From: Sarah Burrow <Sarah.Burrow@arun.gov.uk>
Sent: 22 June 2021 10:09
To: Planning.Responses <Planning.Responses@arun.gov.uk>
Cc: Anita Gardner <Anita.Gardner@arun.gov.uk>
Subject: F/5/21/PL - Paynters Croft

Further Engineers Comments Regarding Surface Water Drainage

Drawing No.	Rev.
D1906-300	C

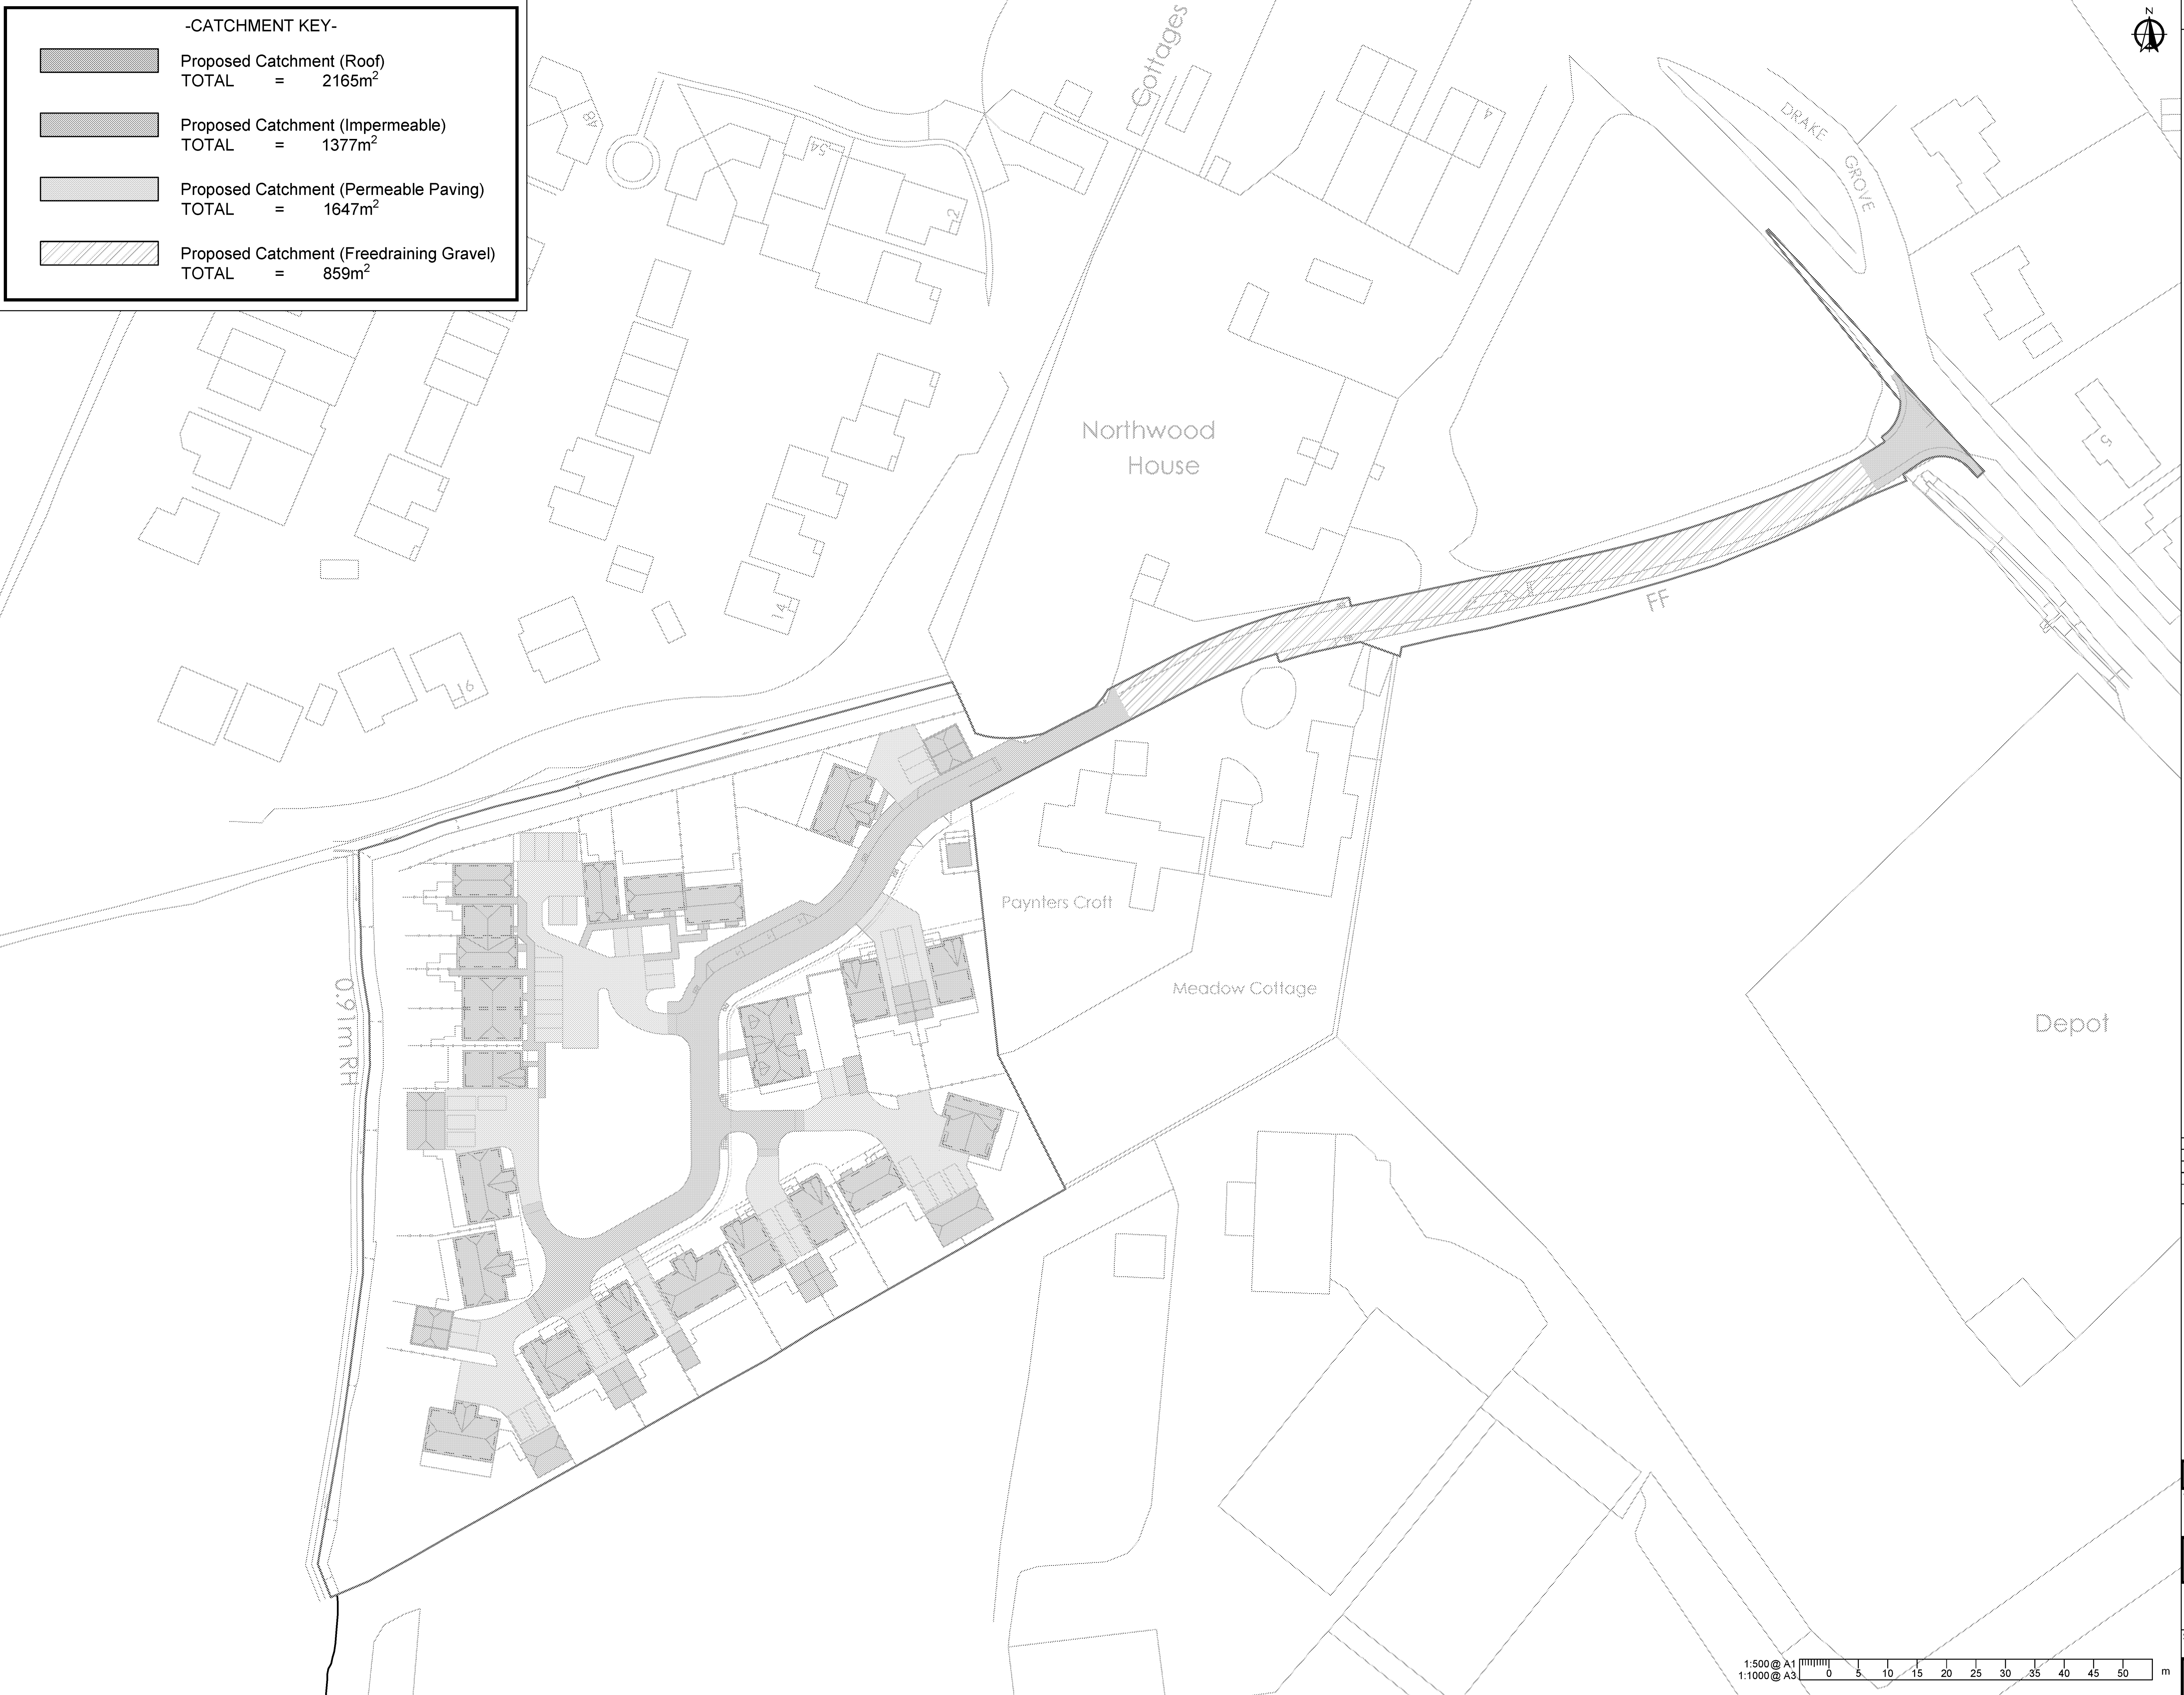
It has come to our attention that there may be complications with the proposed surface water drainage disposal location at this site. A member of the public has approached the department and stated *"The watercourse on the northern boundary of the proposed site, is owned and maintained by the residents of the Abbotsfield estate and therefore should not be included in any development plans without first communicating with ALL the Residents."*

The surface water disposal location is critical to the agreed layout as there are no options for a route through public land to a disposal location at the western boundary.

Therefore I wish to alter my consultation response to a **holding objection**. In order to overcome this objection the applicant will need to do **one** of the following:

- Provide evidence that they have riparian rights to connect to the northern watercourse without requiring permissions from the Abbotsfield Estate. OR
- Provide evidence that they can gain permissions from the residents of the Abbotsfield Estate to connect to the northern watercourse. OR
- Alter the layout to provide a connection route to the western watercourse on public land (i.e. not through proposed private gardens).
